Subject: Walla Walla Solar Farm MOD 2 – Project Layout Changes (SSD 9874 MOD 2)

BCD has reviewed the documentation provided, including the Biodiversity Development Assessment Report (BDAR) in Appendix B.1 to the 'Modification 2 Application Report' (NGH 2022).

ATTACHMENT A – BCD comments on Walla Walla Solar Farm MOD 2 – Project Layout Changes (SSD 9874 MOD 2)

Figure 3-6 Vegetation zones at the development site and floristic plot locations

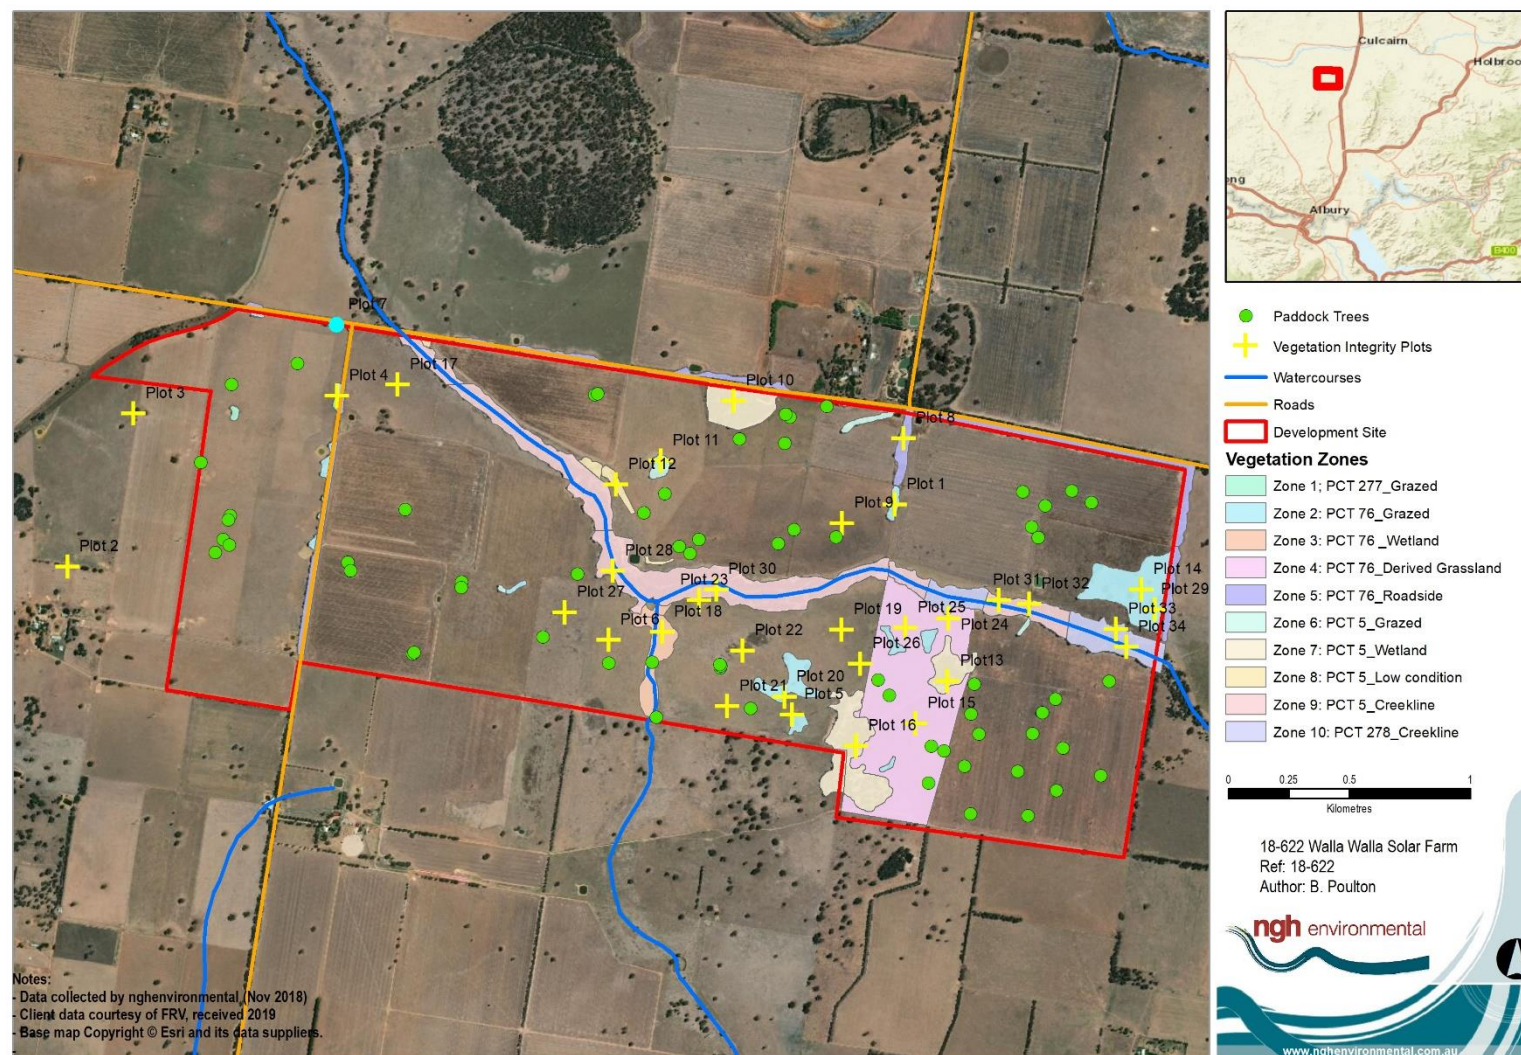
- a. Not all vegetation integrity plots shown on Figure 3-7 are included in the submitted spatial data. Please provide one point only for each plot (coordinates of point 0 on midline transect, as per s3.4.1 of the BAM 2020 Operational Manual – Stage 1 (DPIE 2020).
- b. The scanned field data sheets are not easily matched with the spatial data or the dataset in Appendix B. On review, the datasheets submitted with the original project Environmental Impact Statement (EIS) are clear, easy to understand and appear to be more correct than those submitted for Mod 2.
- c. The submitted plot location shapefile appears to be arbitrarily numbered with Plot ID. Coordinates of points do not match the scanned datasheets submitted with the EIS, e.g. Plot 27 scanned datasheet E:496435 N:6043866; Plot 27 in shapefile E:497623 N:6043822.
